TOWN AND COUNTRY PLANNING ACT 1990

FULL

Reference: H02-0033-26 **Date of Decision:** 16th March 2026
Applicant: Mr M Woodroffe
32 West Street
Crowland
Peterborough
PE6 0ED
Location: Land To Rear Of 53 West Street Crowland Peterborough
Description: Construction of new detached dwelling

Site Section - North/South

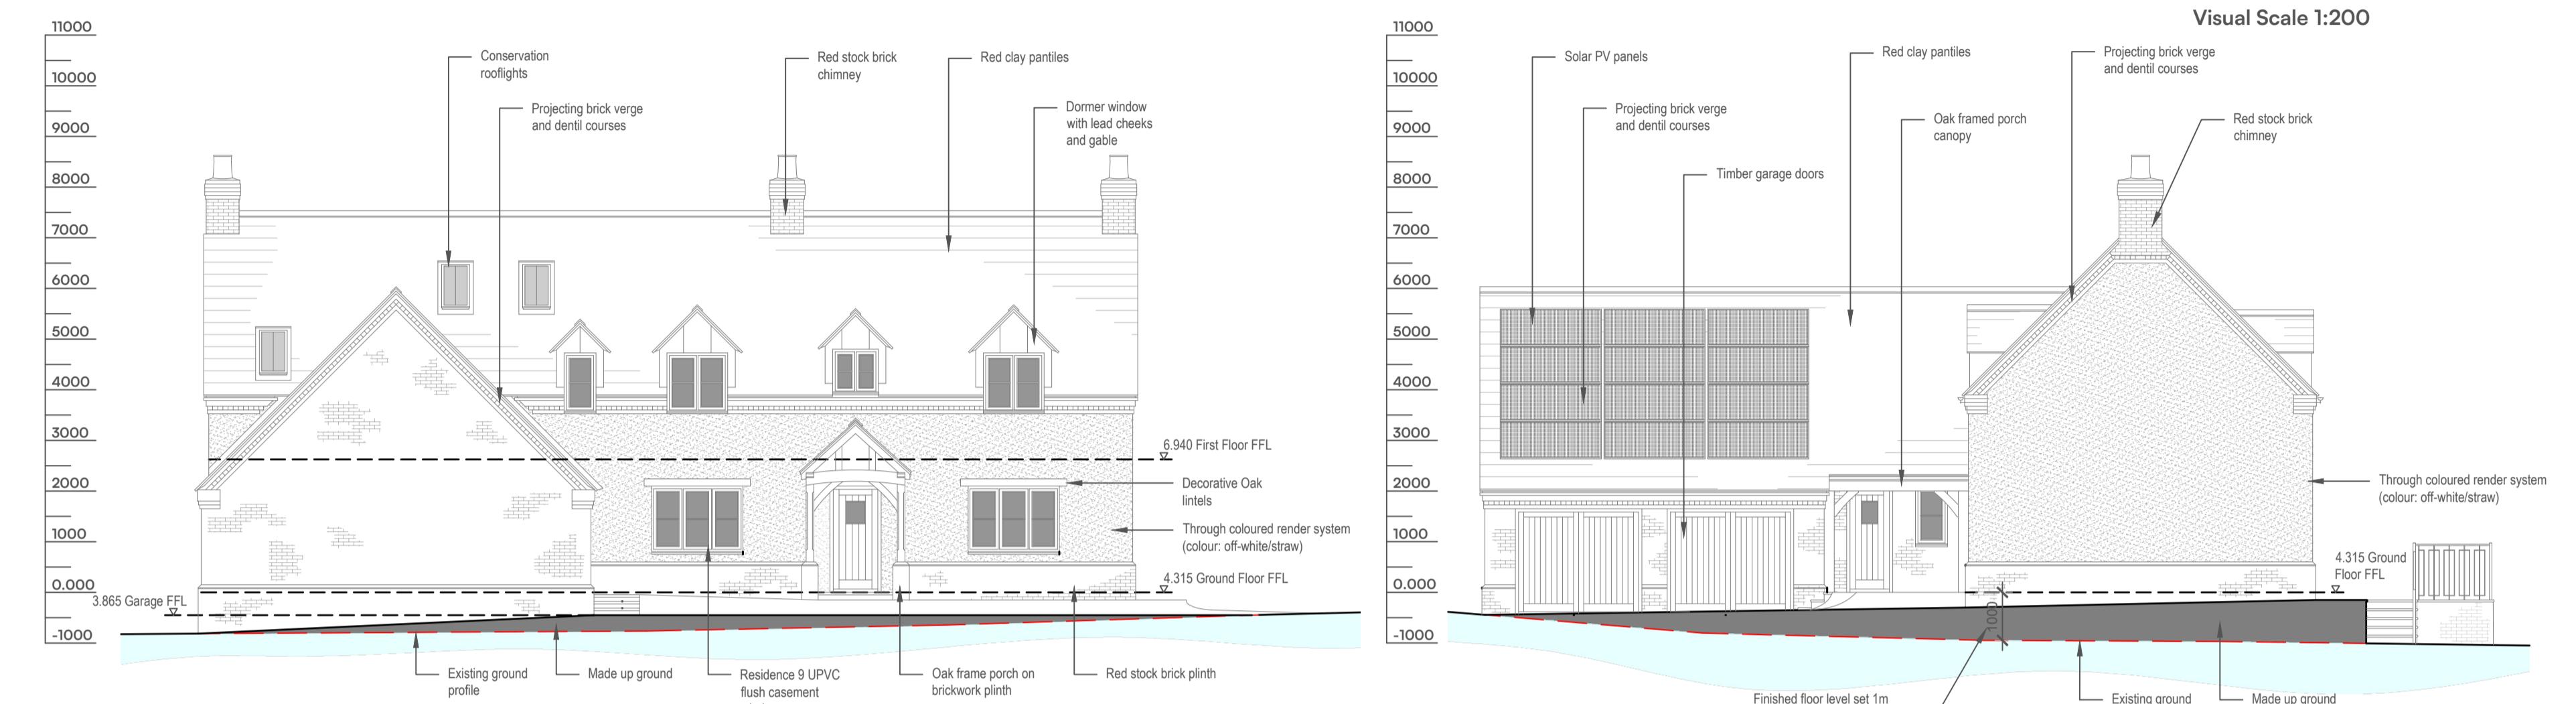
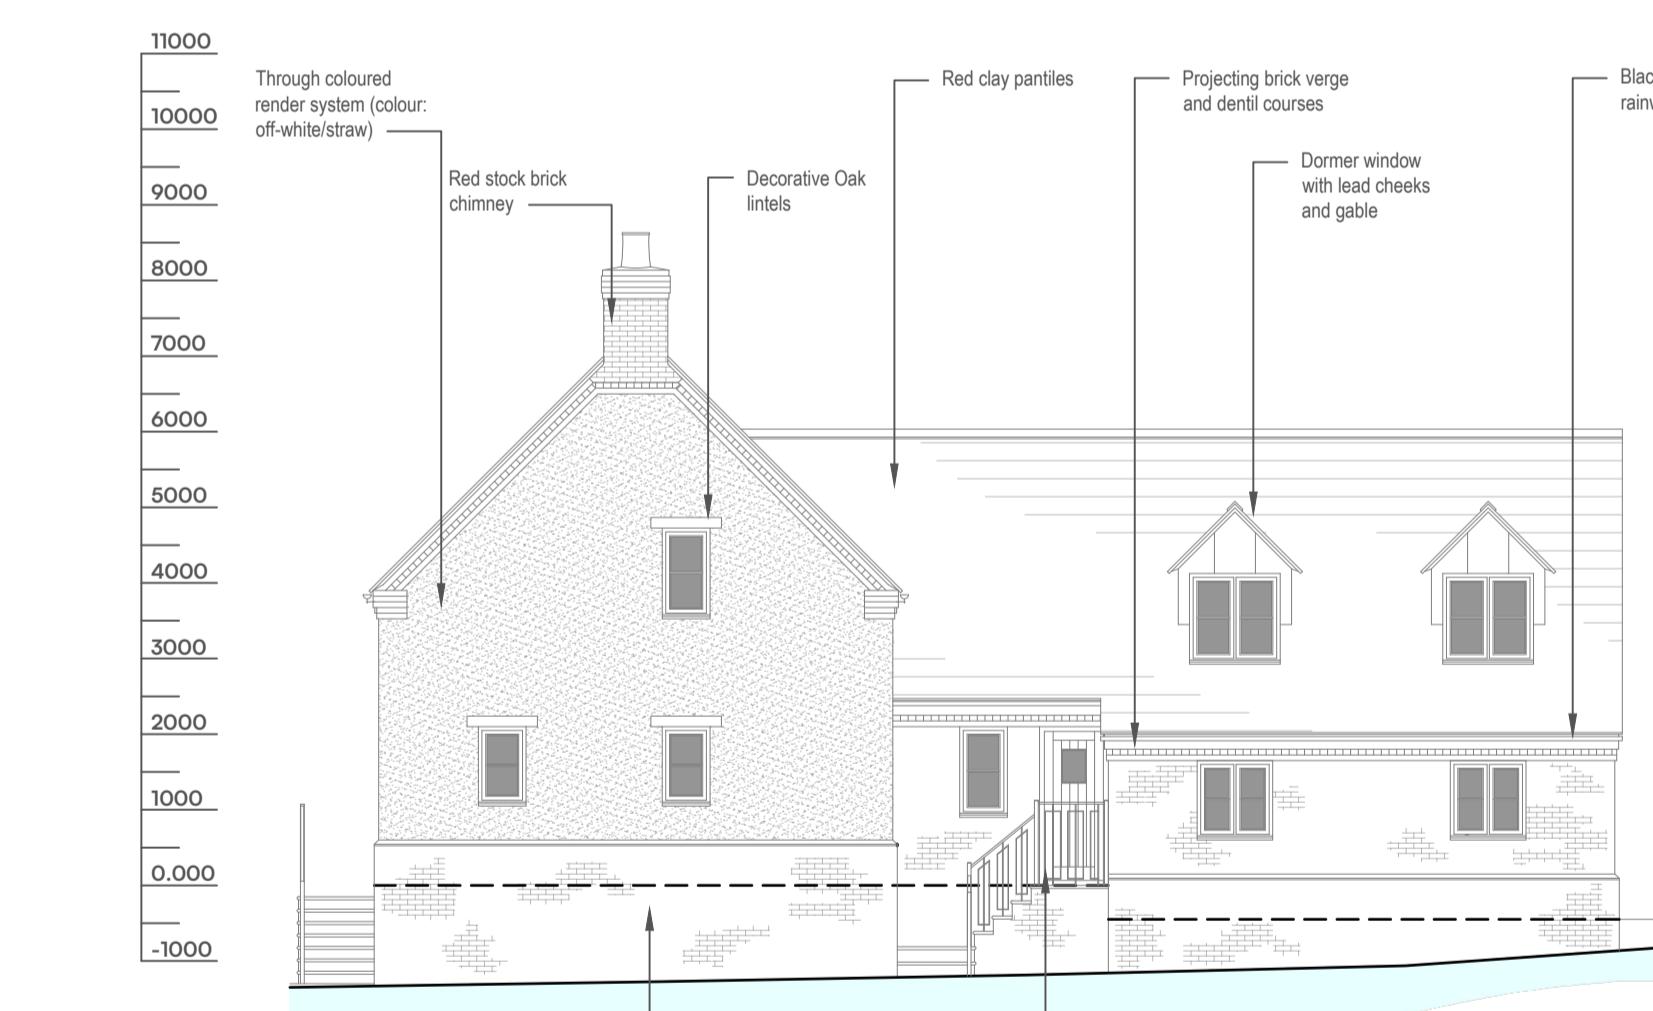
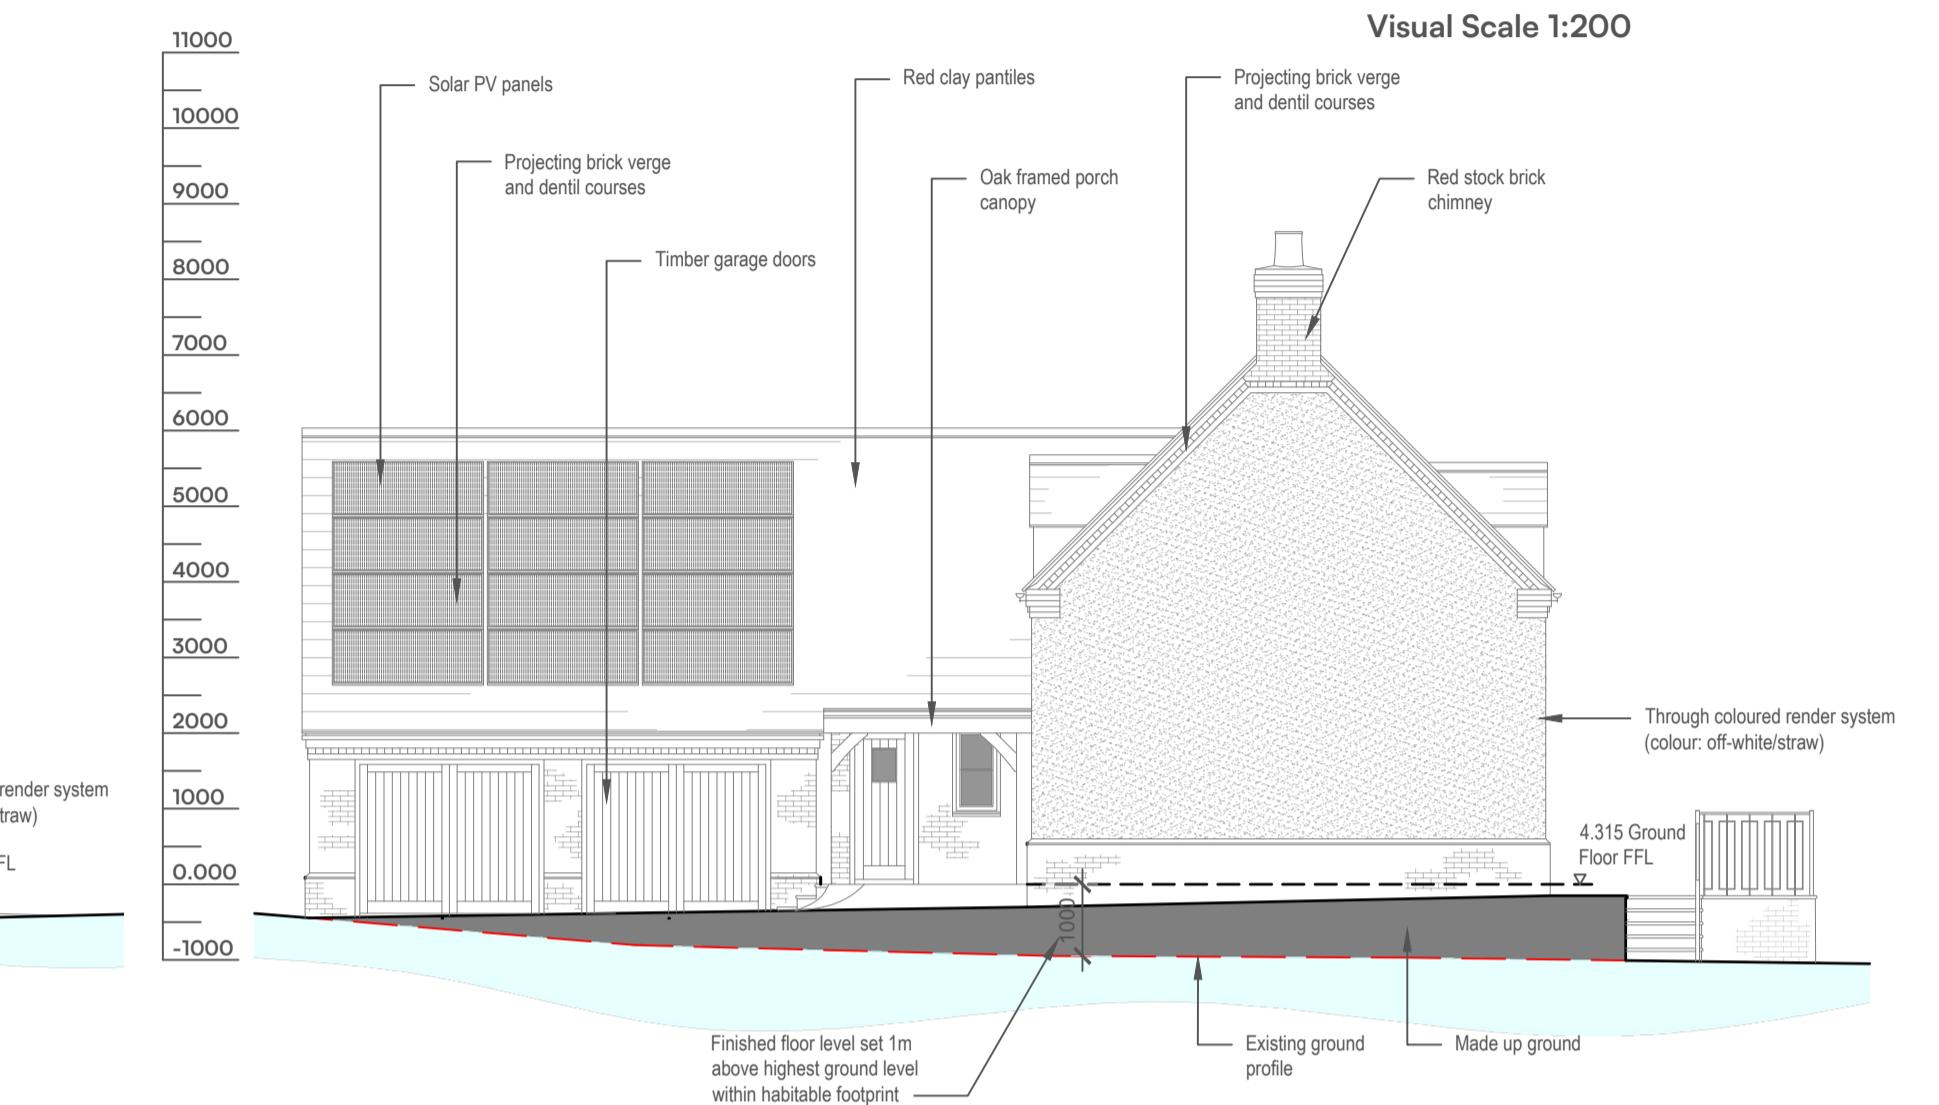
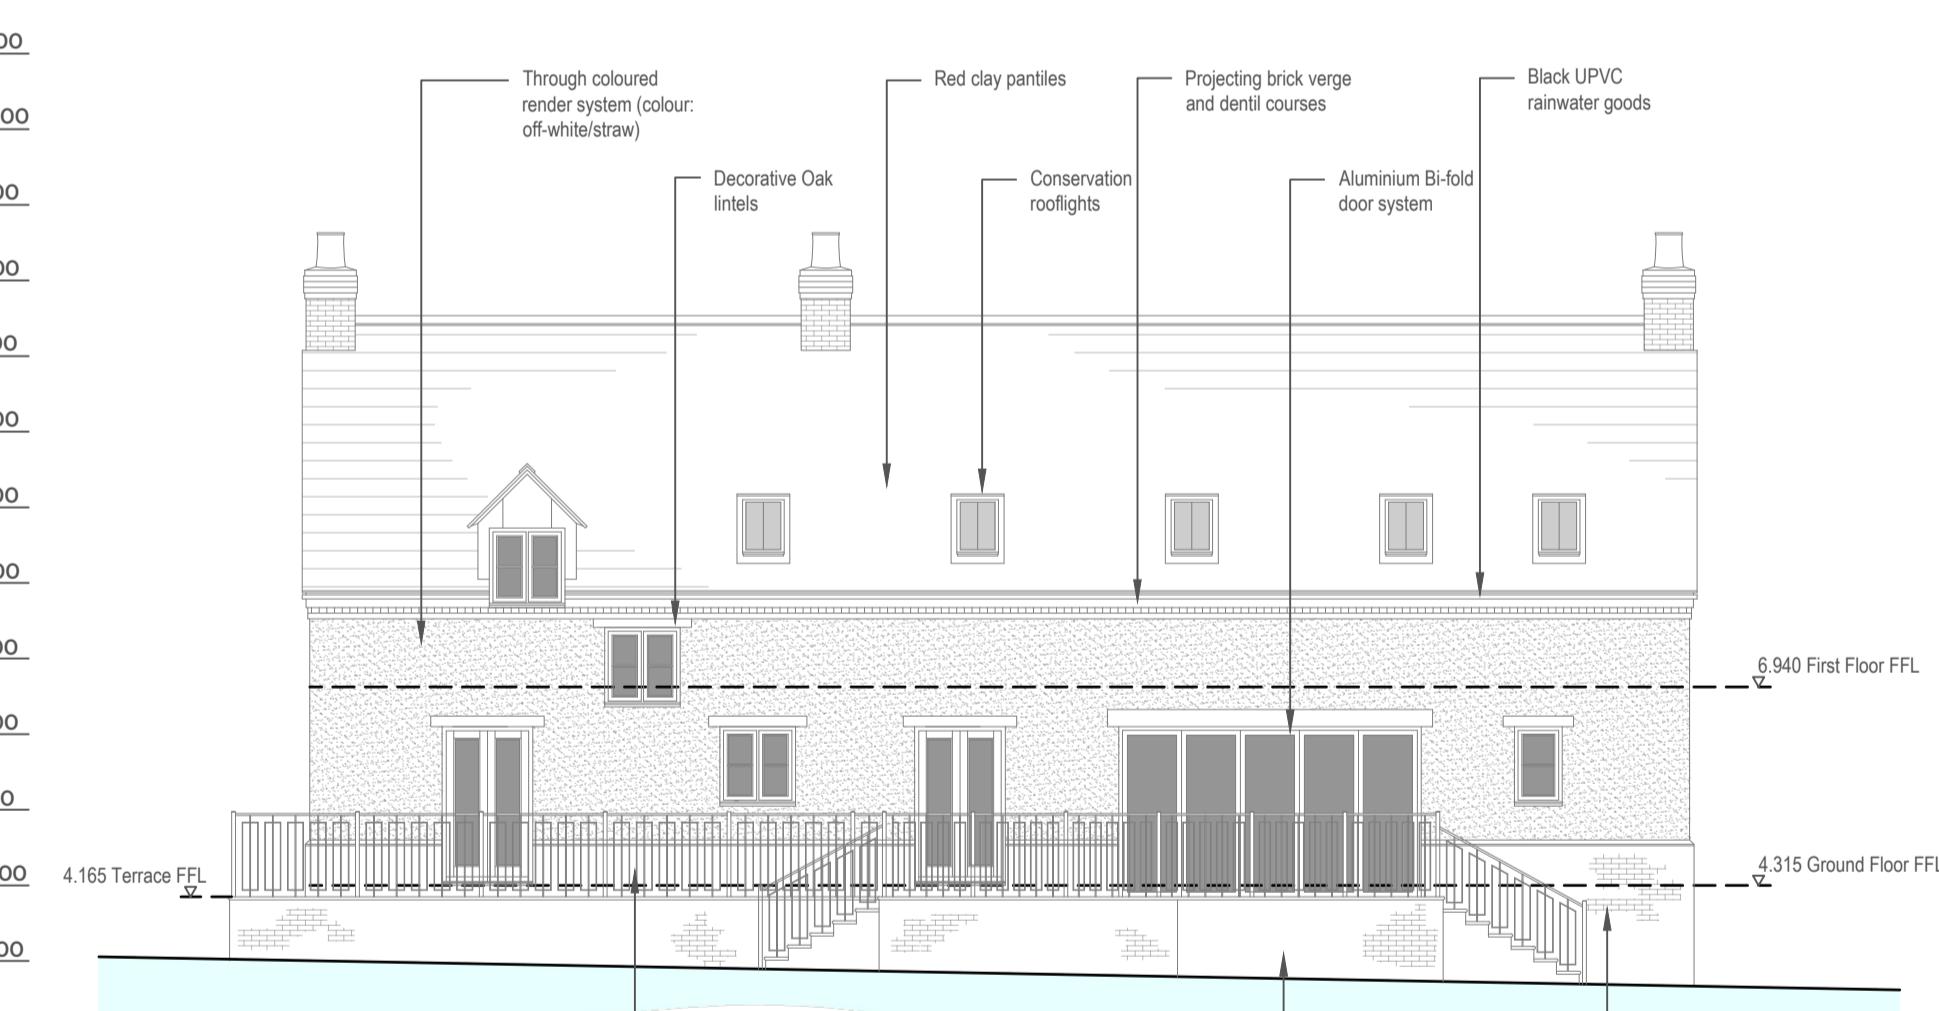
- 1 The overall scale of the proposed dwelling is considered to be out of keeping with the area and as such, the visual impact of the development is considered to be unacceptable. Therefore, in visual and amenity terms, the proposal fails to accord with Policies 2 and 3 of the South East Lincolnshire Local Plan (2019) and Section 12 of the National Planning Policy Framework (December 2024), which amongst other things, seek to ensure that the design of all development is appropriate to the character and quality of the area.

- 2 It is considered that the proposed development would result in an unacceptable degree of overlooking and would result in overbearing environment, as a result of the siting and height of the proposed dwelling and the raised platform area along the eastern edge of the site. Therefore, the development is contrary to Policies 2 and 3 of the South East Lincolnshire Local Plan (2019), which, amongst other things, require that development should not adversely affect residential amenity or health. The development is also considered to be contrary to Paragraph 135 of the National Planning Policy Framework (December 2024), which sets out that planning decisions should create places with a high standard of amenity.
